Recommendation Report for Planning Permission for Works or Extension to a Dwelling

REF NO: FG/128/21/HH

LOCATION: 23 Little Paddocks
Ferring
BN12 5SN

PROPOSAL: Rear first floor extension & front balcony/inset dormer.

PROPOSED ALTERATIONS

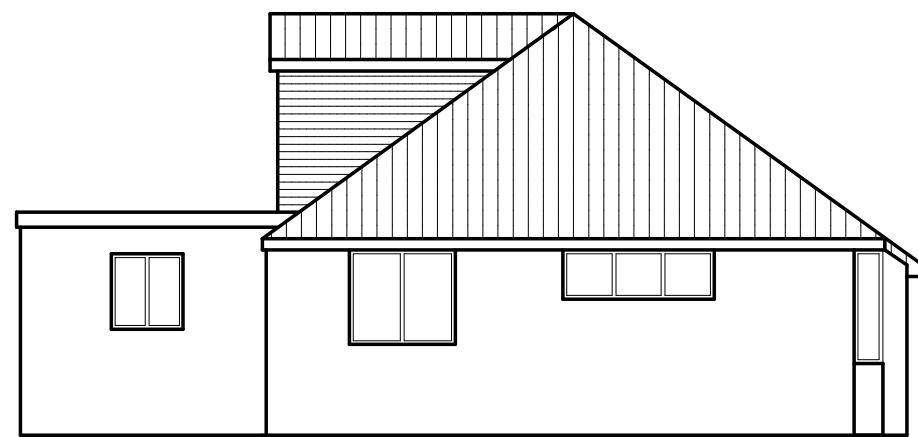
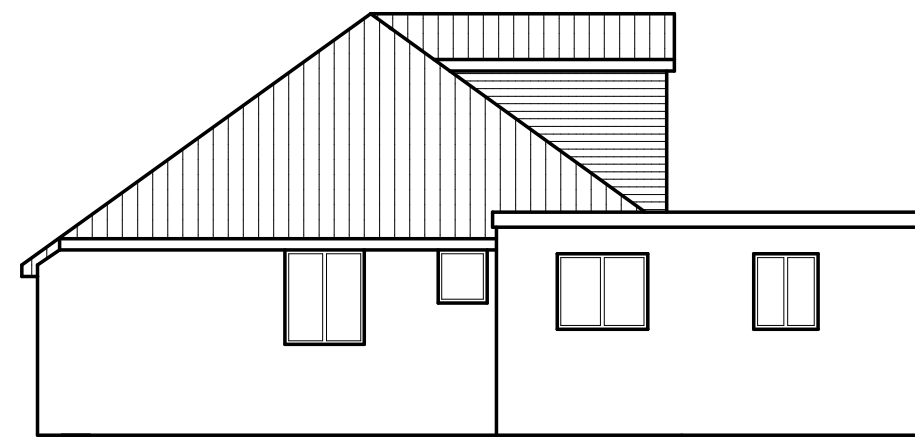
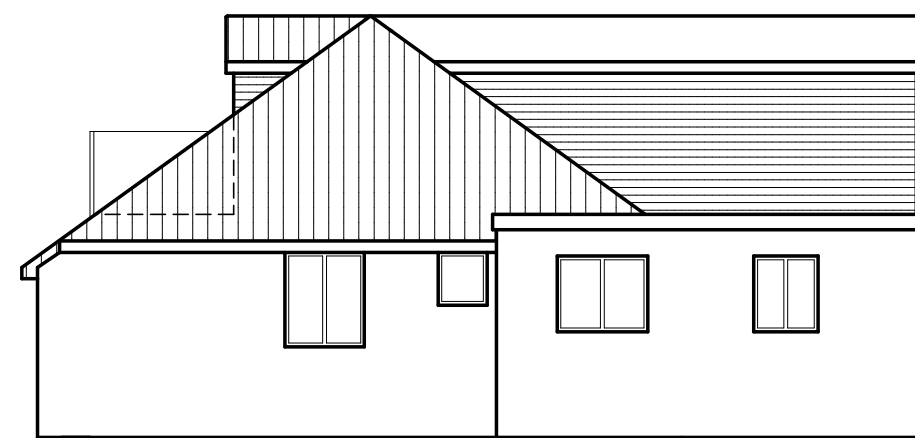
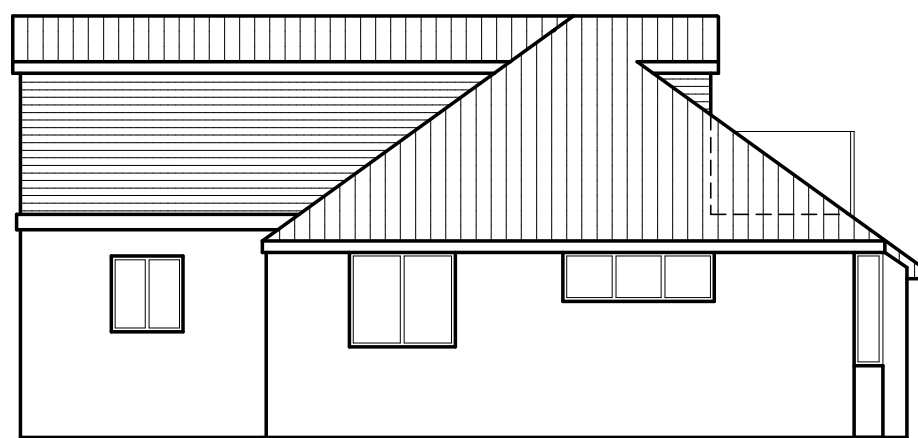
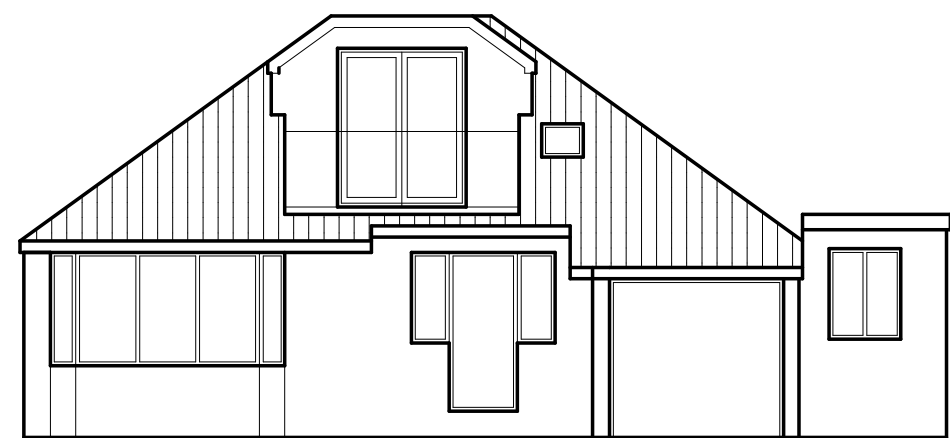
The rear extension will replace a smaller dormer which currently sits within the existing roof space of the dwelling. To accommodate the first-floor extension, it is proposed to undertake a hip to gable conversion, on both the eastern and western elevations. The extension will spring off the exterior wall of an existing single storey flat roof extension which has the effect of creating a full two storey elevation, with a false pitched roof. Consequently, all the existing southern plane of the roof will be lost. As the design qualities and character of the chalet bungalow are completely lost at the rear, it is considered that the scale, form

and design of the proposed first-floor extension is visually dominant on properties to the rear by visually creating a two storey property, and does not integrate well with the host dwelling in conflict with policy D DM4 of the Arun Local Plan.

Having regard to the design and visual amenity, the proposal is deemed to conflict with DDM1 and DDM4(a) (b) of the Arun Local Plan and the Part M Arun Design Guide as the creation of a fully two-storey property will be unduly dominant and visually unintegrated with the host dwelling to the rear.

FIRST FLOOR PLAN

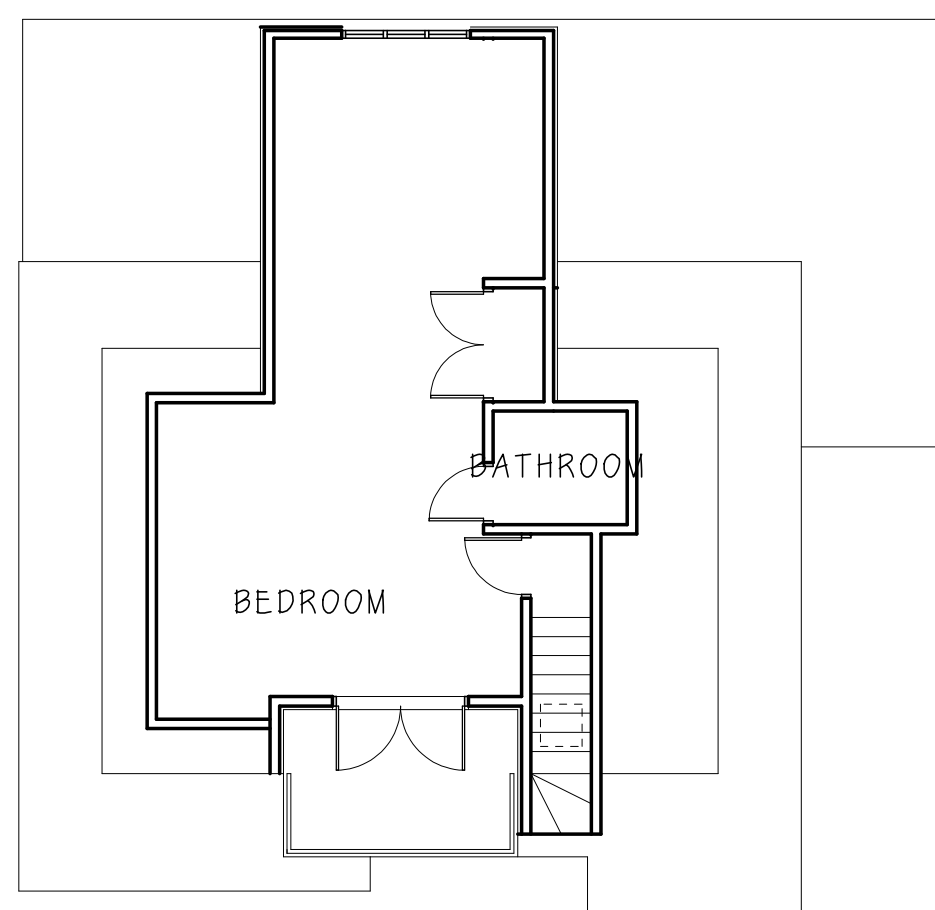
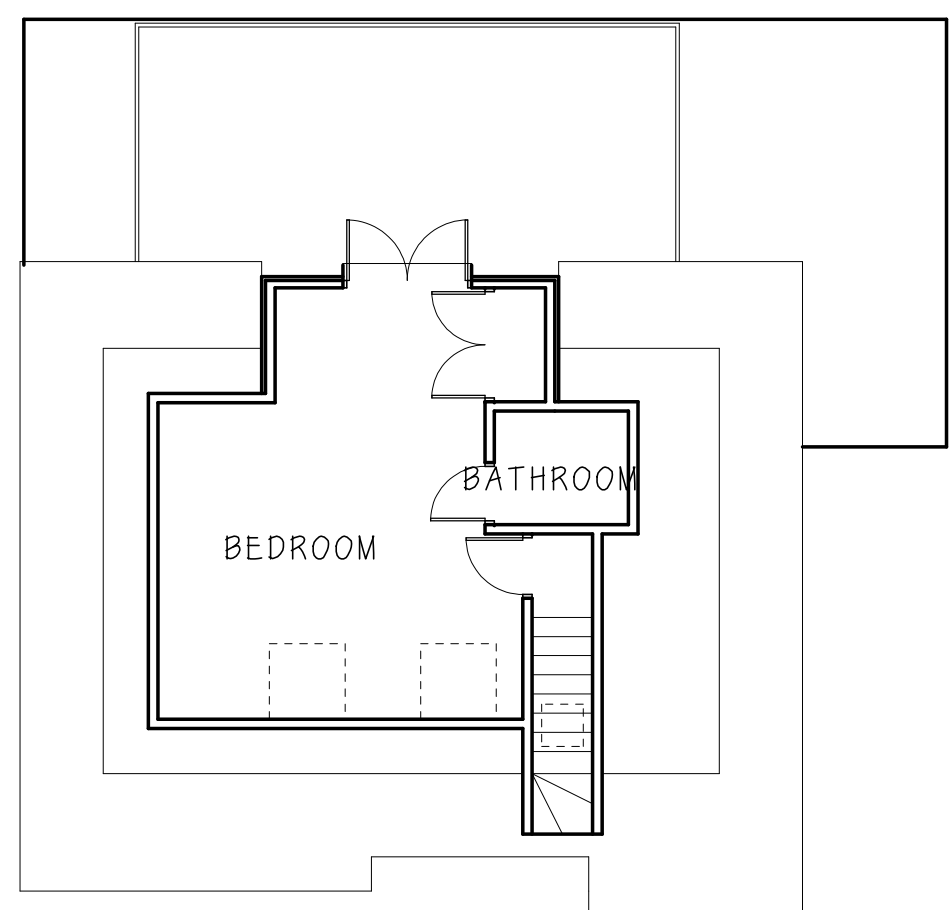
The proposal seeks to provide two extensions to the previously converted roof space, one dormer extension to the front (south) measuring 3.5m wide, and the other significantly larger first-floor extension to the rear (north), measuring approximately 10m in width and almost 4m deep, which is proposed over an existing single storey extension. The rear first-floor extension has the effect of creating a further storey to the house rather than solely being a rear dormer loft conversion. No changes to the ground floor are proposed.

The proposal increases the area of the first floor by over 60 square meters which is roughly a 200% increase on the amount of first floor accommodation. Whilst an extension above an existing structure is an effective use of the land it needs to be respectful to the host dwelling and spatial character of the area.
